SLAE Written Representation Submission for Deadline 7.

Hydrogeological.

TR020001-002162-5.02 Environmental Statement Appendix 20.6 Hydrogeological Risk Assessment Report - Drainage Rev1

TR020001-002138-5.02 Environmental Statement Appendix 20.3 Hydrogeological Characterisation Report Rev 2

Figure 2: Rainfall at Runley Wood Pumping Station

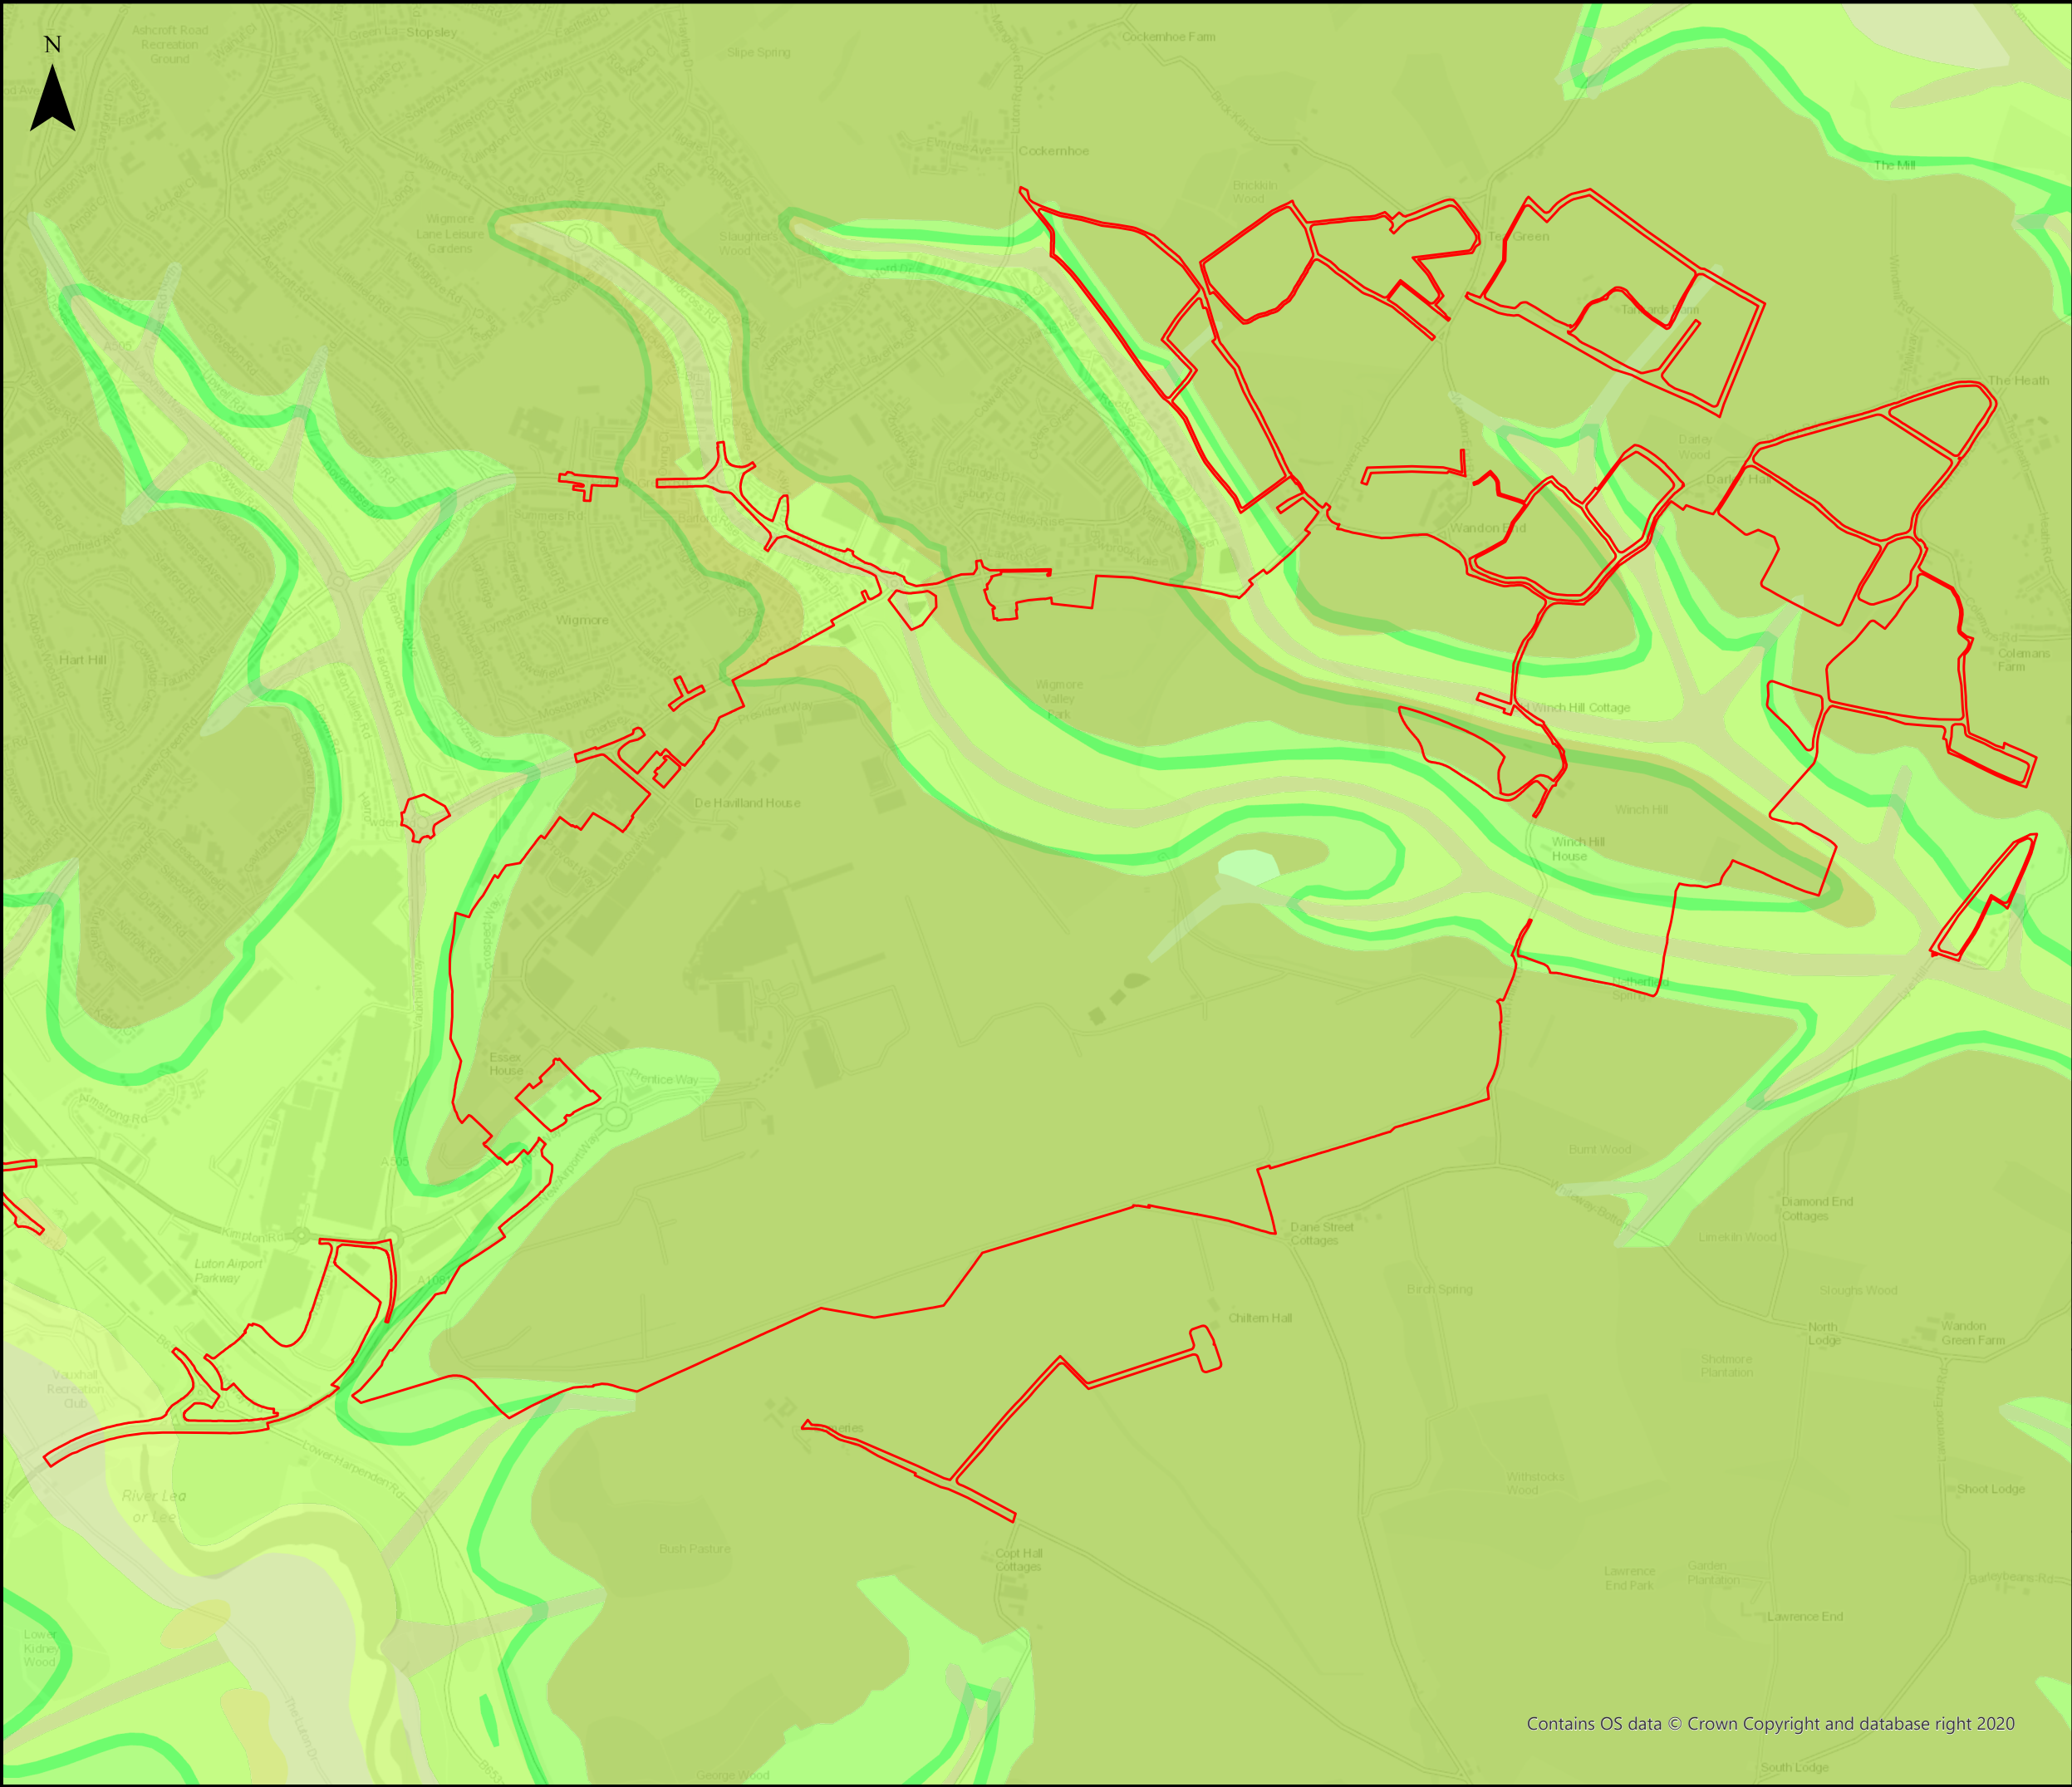
Like LR's definition of 'local' etc, How far is 'nearby'? LU1 1UB, Runley Wood is 4.9 miles away and near Dallow Road. This questions the monthly rainfall values as Runley Wood is on a plateau and Luton Airport is on the top of a Hill. It would be more accurate to measure like for like.

Figure 9 – Groundwater Hydrograph from Monitoring (Beneath WVG Landfill)

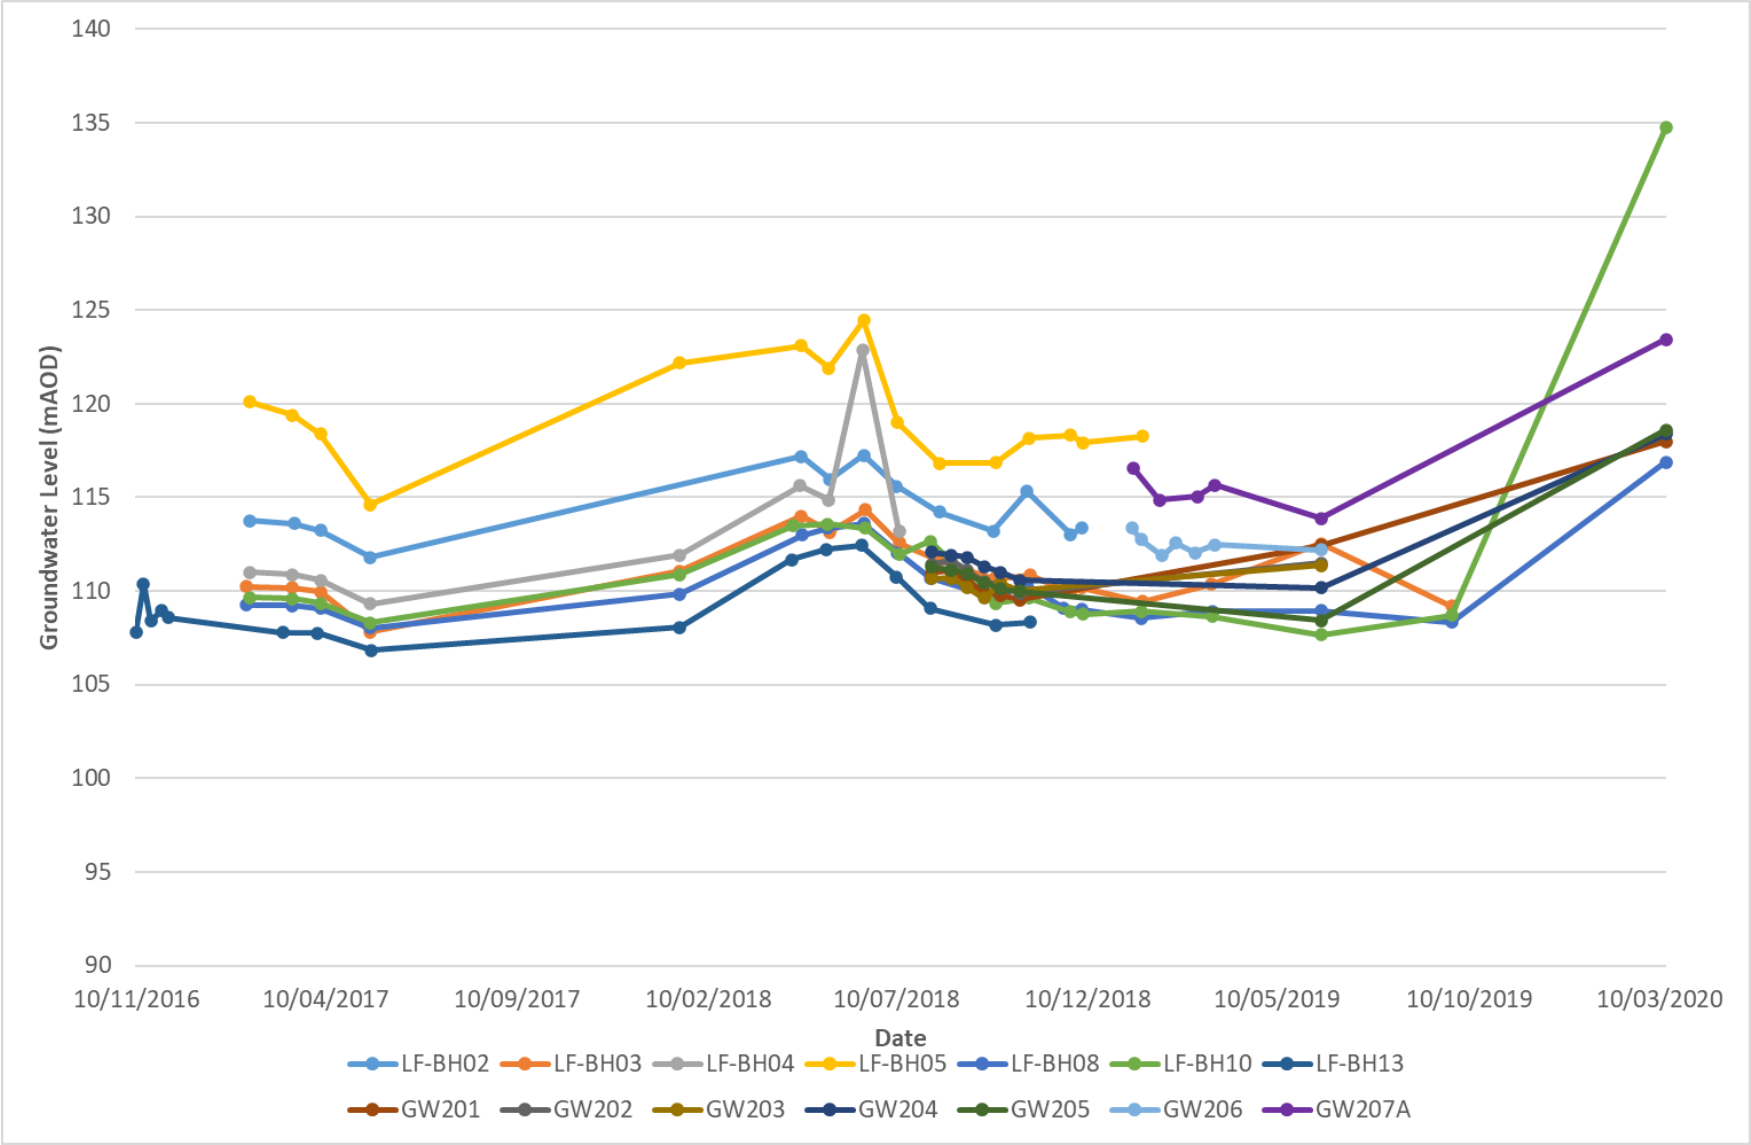
Have further tests been carried out? It might be wise to undertake further tests following the recent rainfall since November, December (2023) and January (2024) that has been experienced, to confirm if the reading is anomalous?
